PLANNING AMENDMENT

H09/870/02/A1

Description: Extension & alterations

Location: 51 Spalding Road
Holbeach

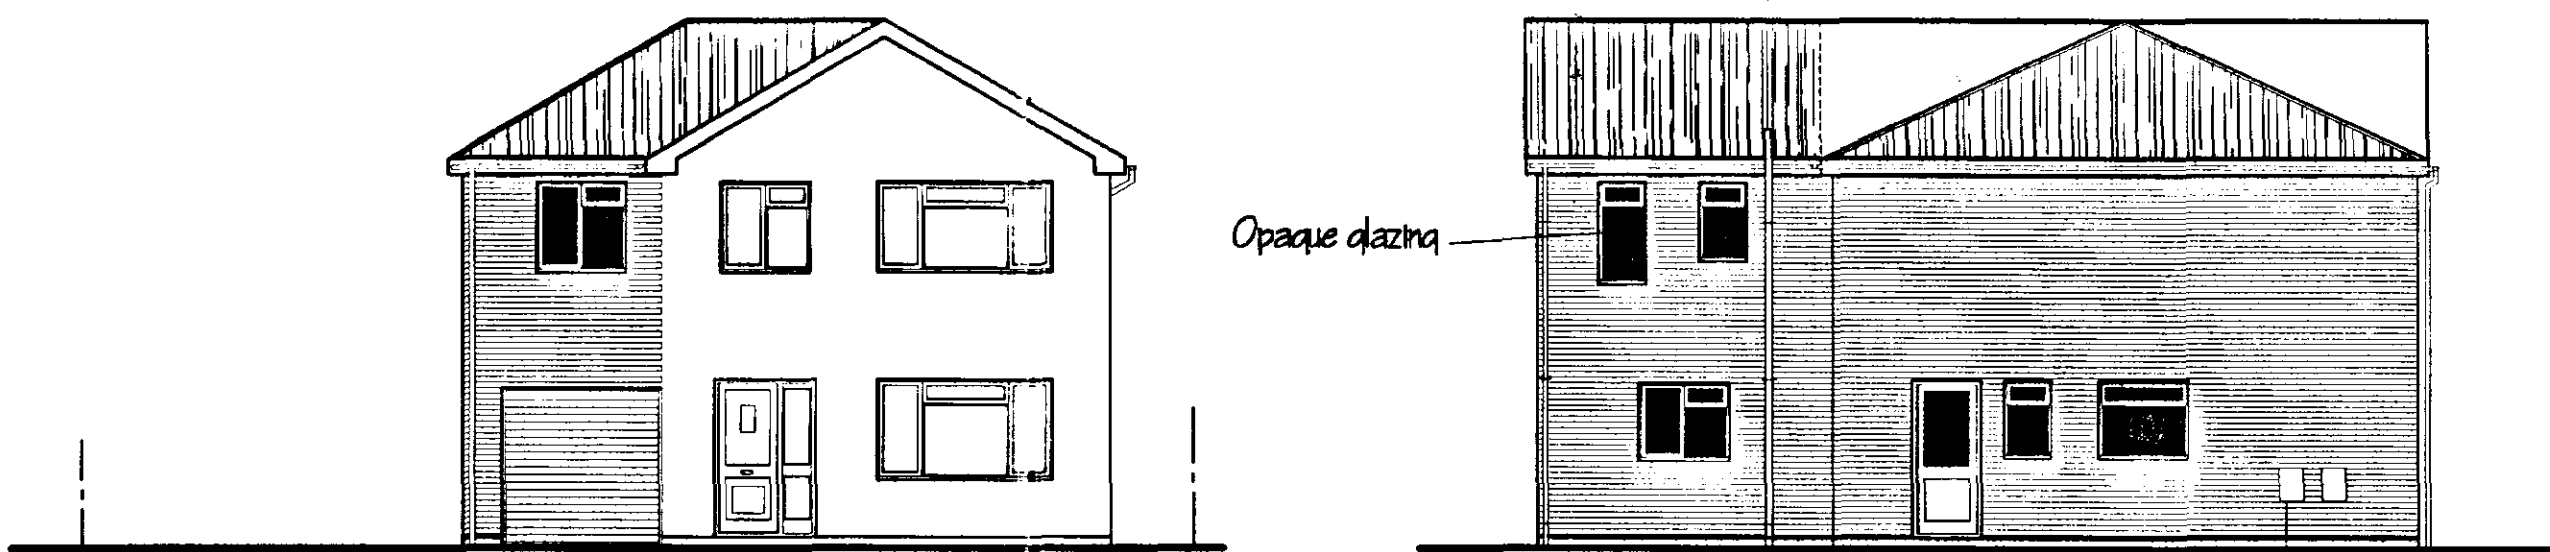
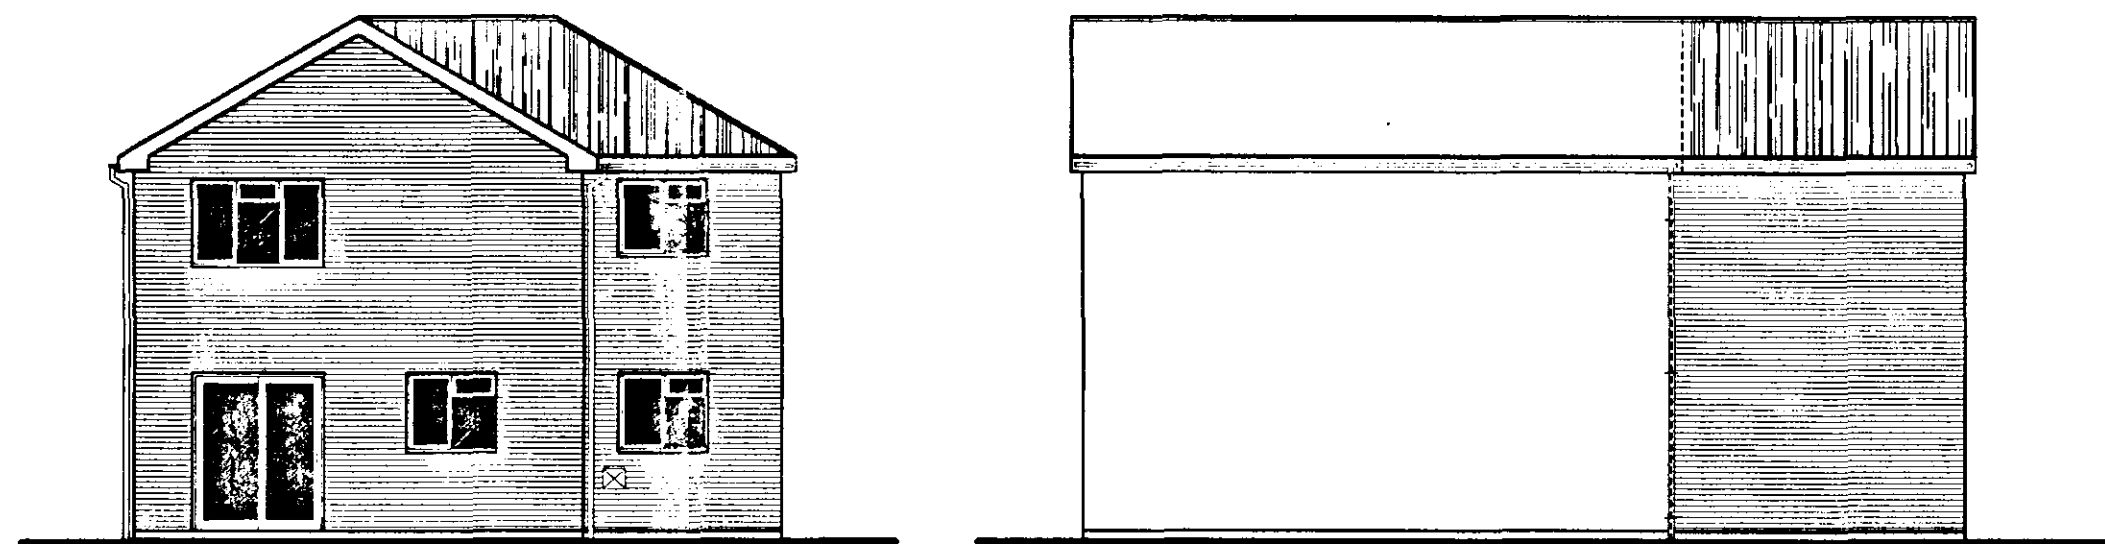
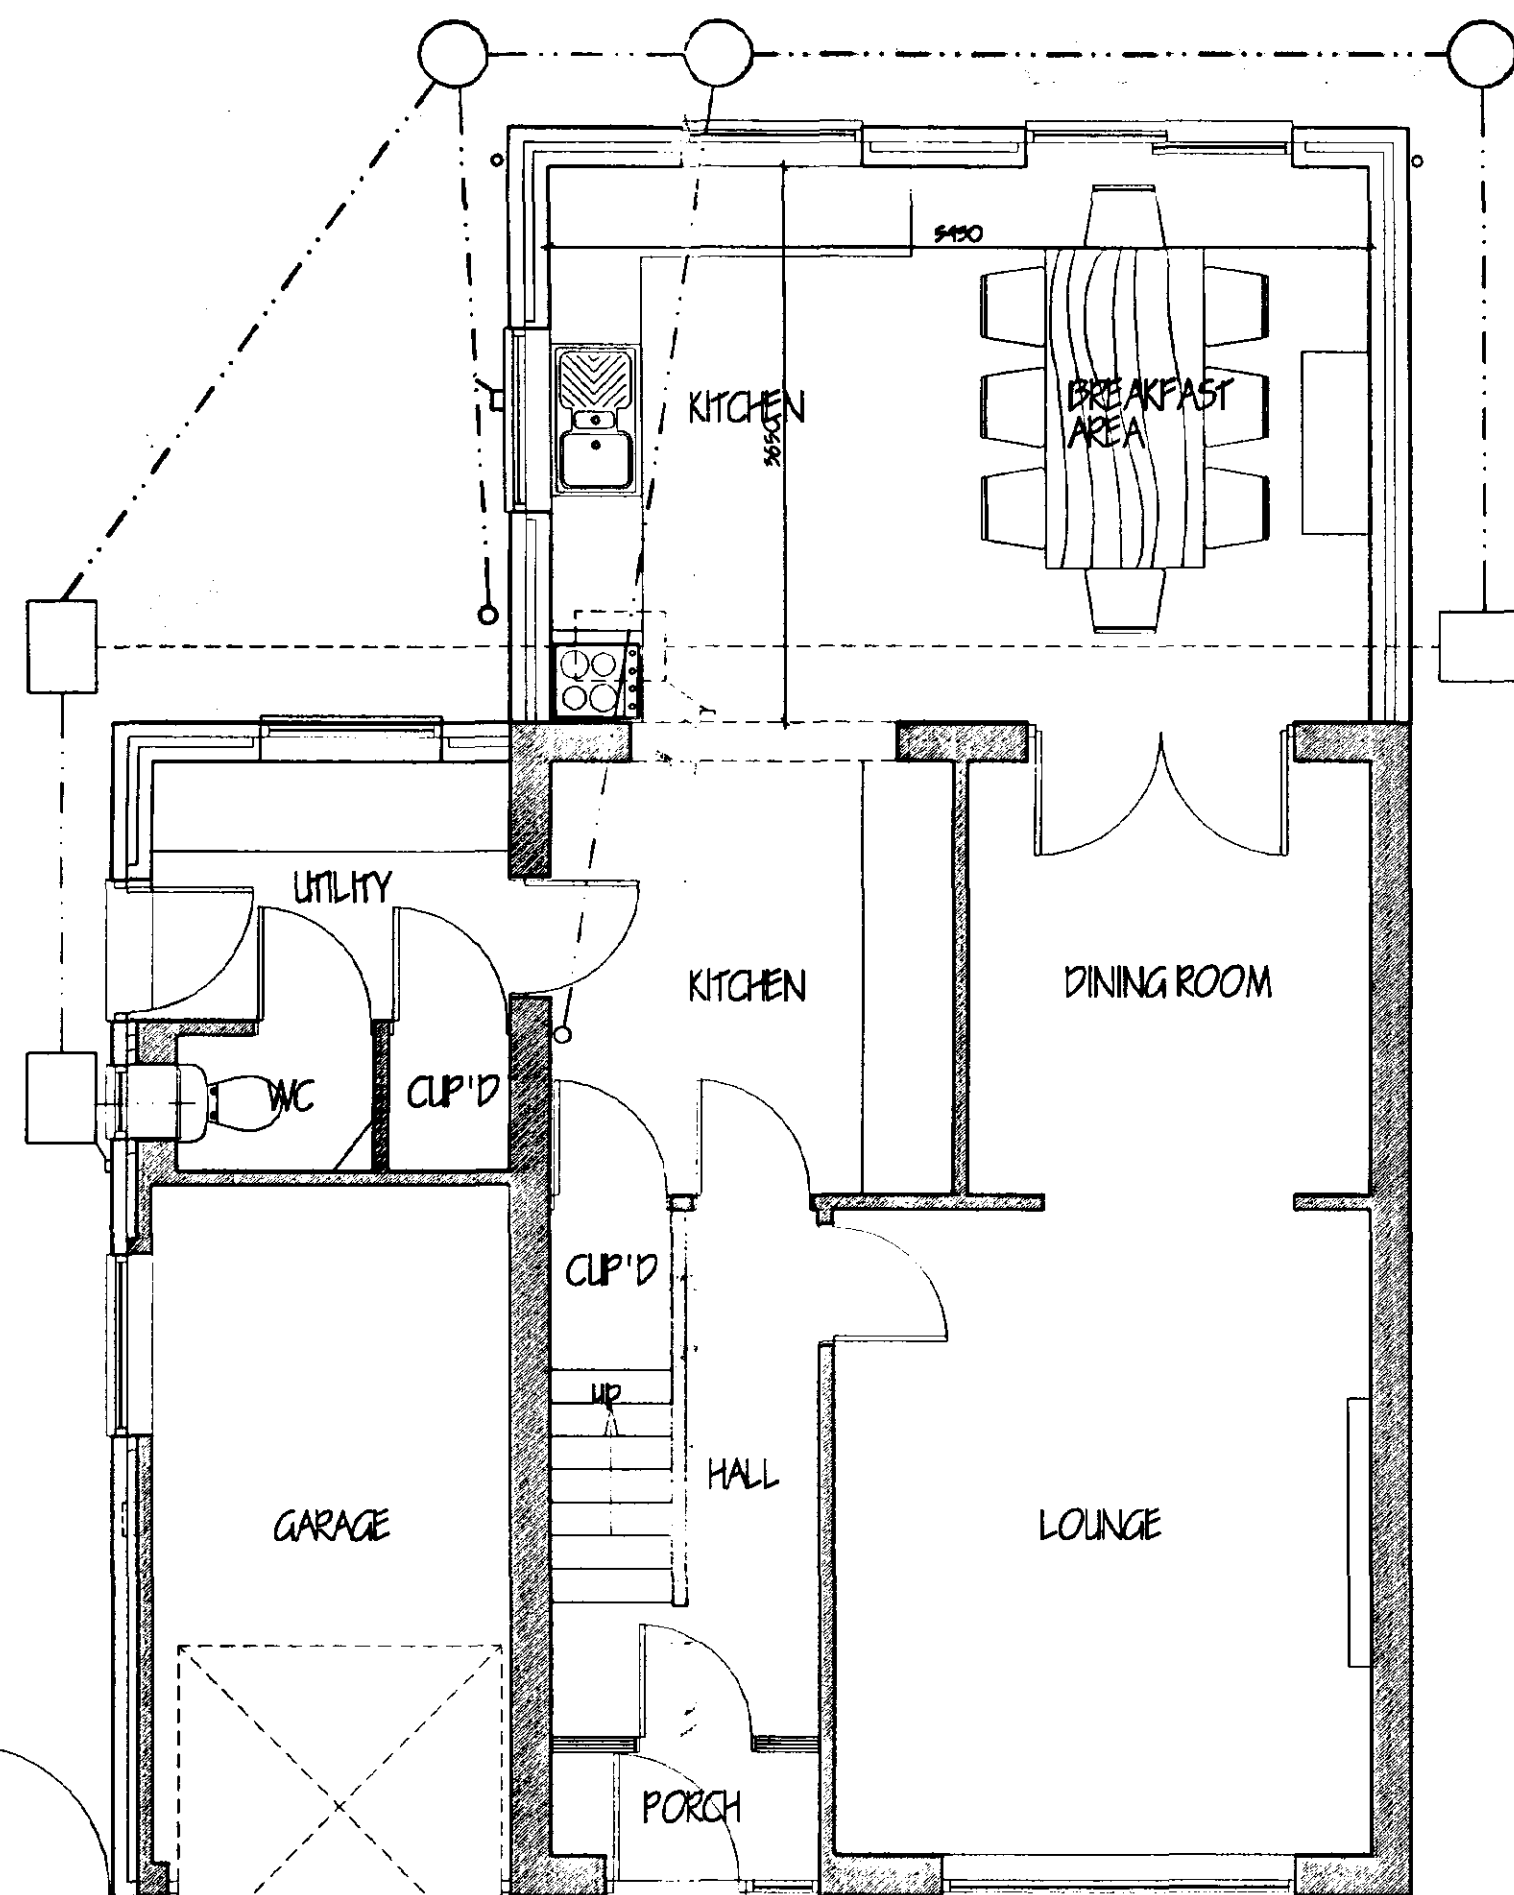
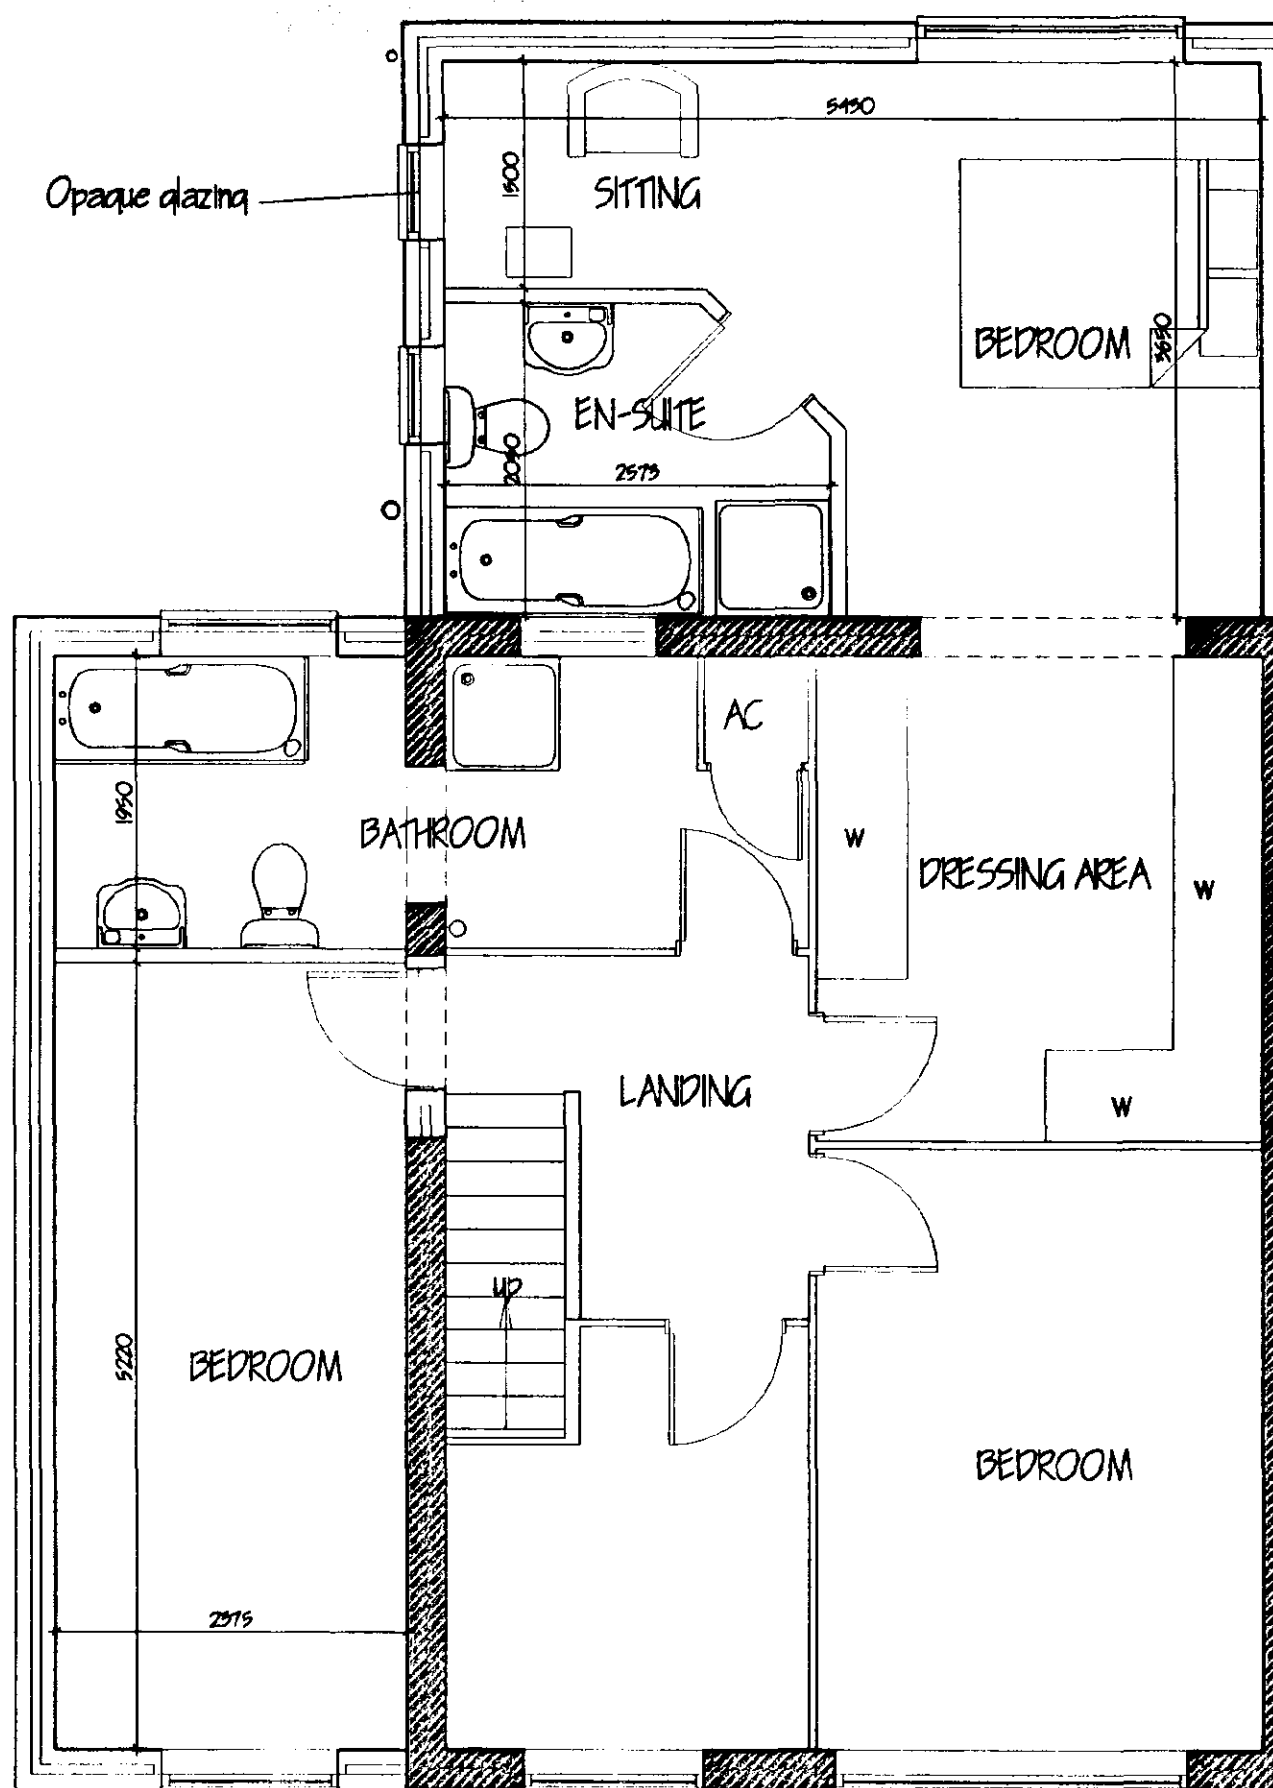
OPAQUE GLAZING TO SITTING AREA WINDOW

Amendment: Opaque glazing to sitting area window
Dwg no. 05-A
